MEMORANDUM

TO: Nell Donaldson, Planner
FROM: David Senus, P.E.
DATE: June 8, 2015
RE: 72 Bishop Street Efficiencies, Final Level III Site Plan Application

Woodard & Curran has reviewed the Final Level III Site Plan Application for the proposed efficiencies located at 72 Bishop Street in Portland, Maine. The project involves the construction of 30 housing units with 12 parking spaces and associated site improvements.

5 OCS OUTLET APRON AND RIP-RAP DETAIL  
NOT TO SCALE

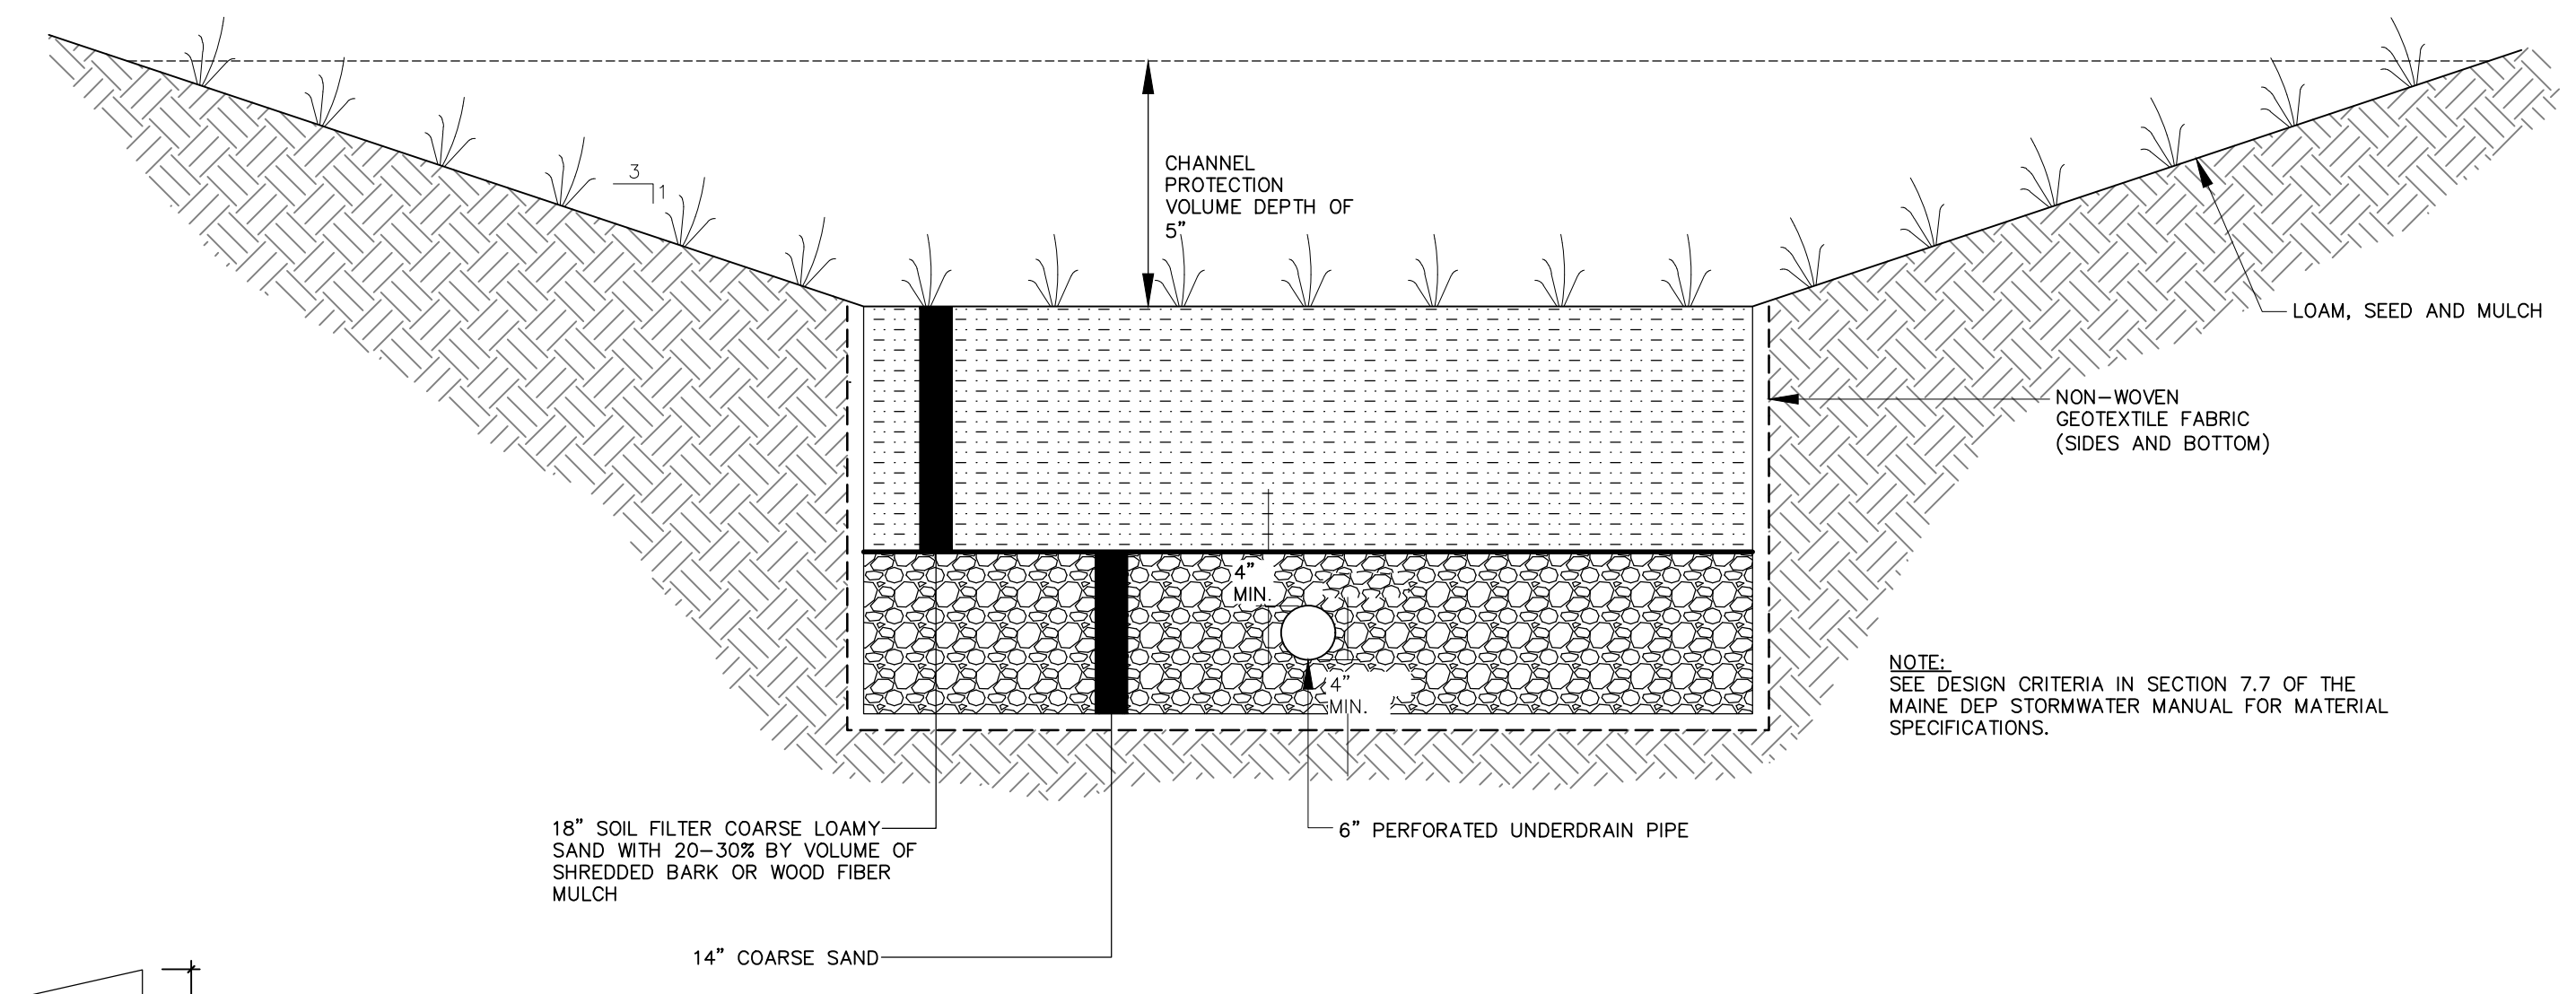
- 10) The OCS Outlet Apron and Rip-Rap Detail provided on Sheet L7 does not specify stone size, stone depth or the width of the outlet control rip-rap apron. The detail should be revised to provide additional design detail; refer to Section E-3 of the Maine Erosion and Sediment Control BMP Manual.

8 VEGETATED SOIL FILTER (WEST SIDE OF BUILDING)  
NOT TO SCALE

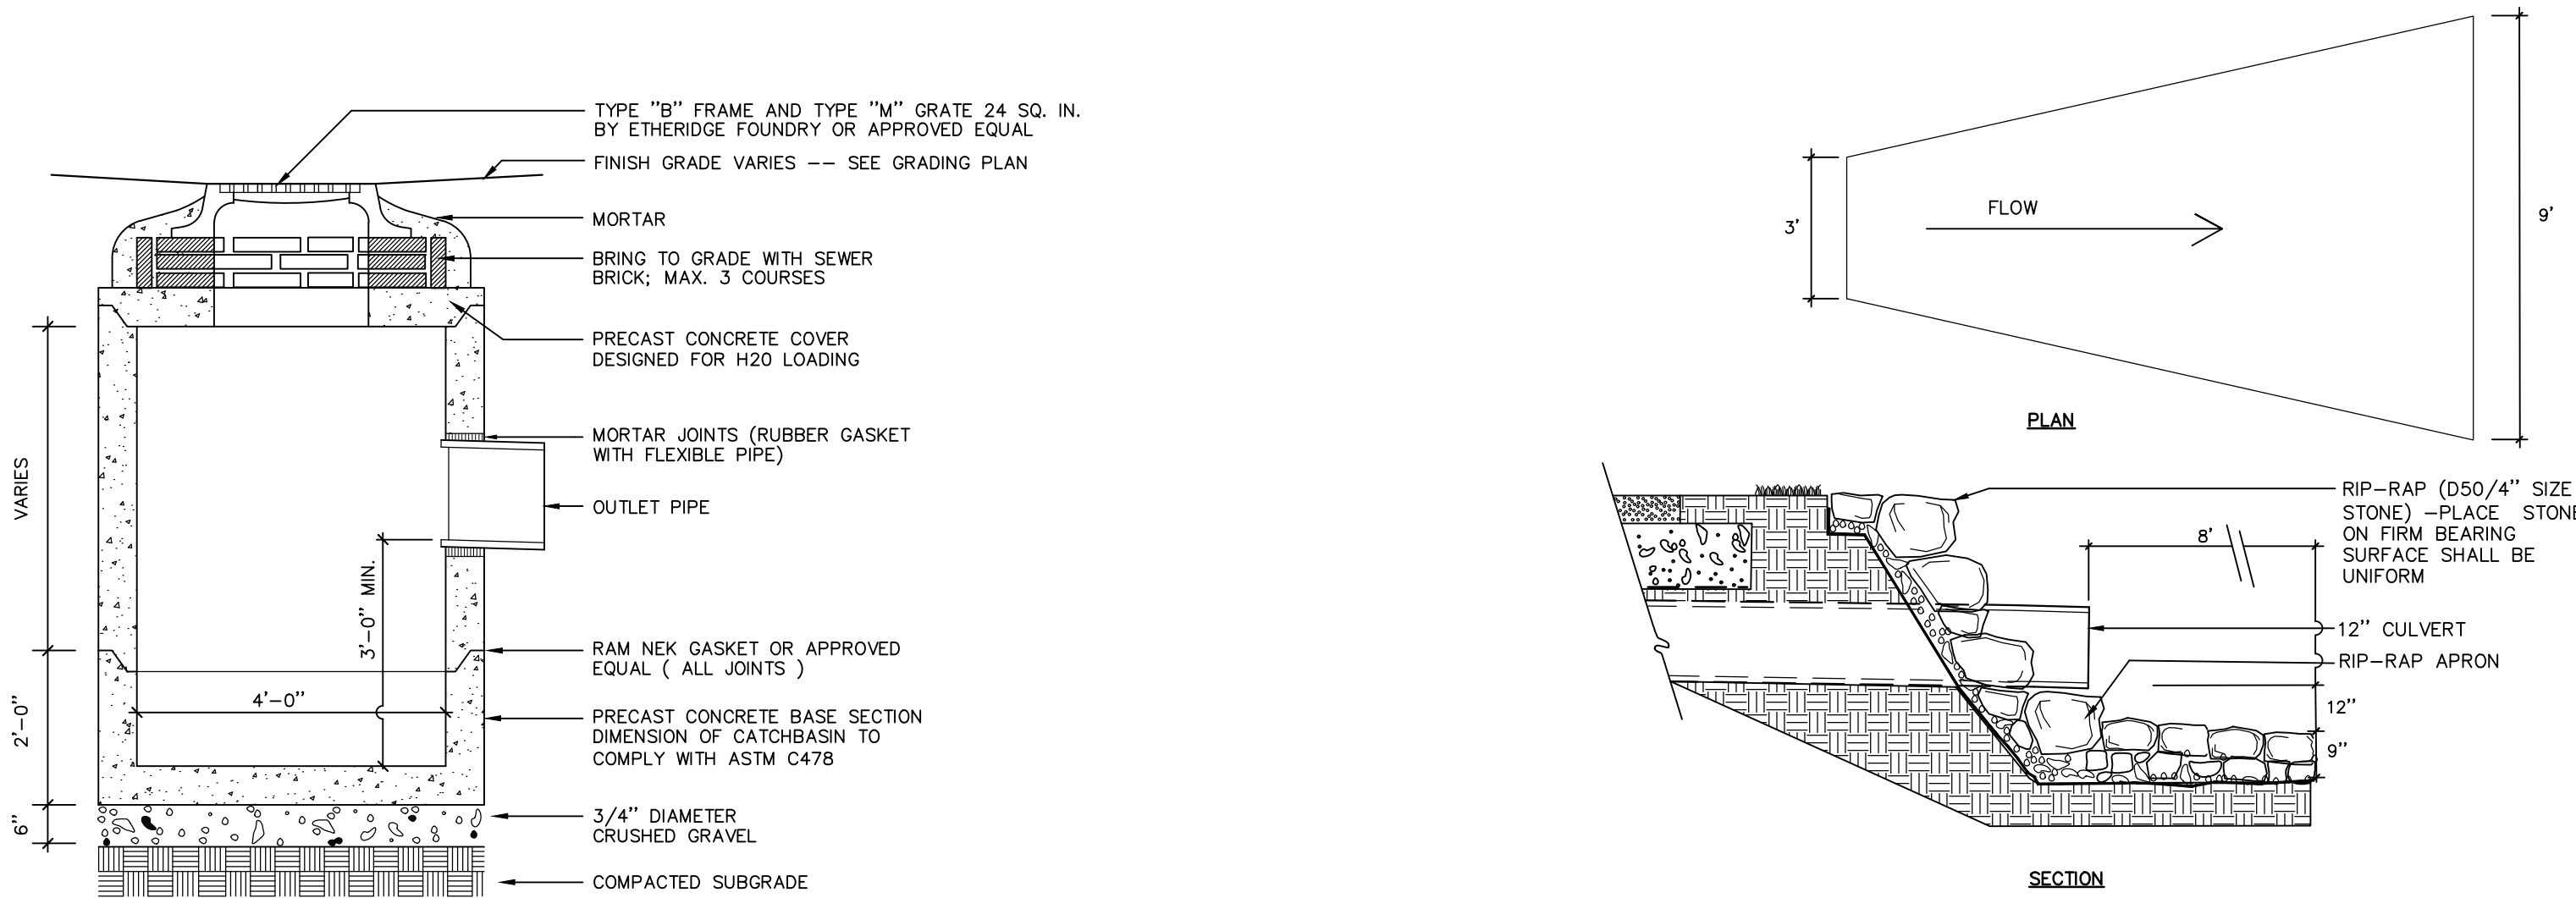
- 9) The Applicant has noted that the stormwater design has been modified to construct a vegetated soil filter with a perforated six inch drain pipe that will connect to the Outlet Control Structure; however, the extent, location and grading of the proposed vegetated soil filter does not appear to be clearly delineated on the proposed plans.
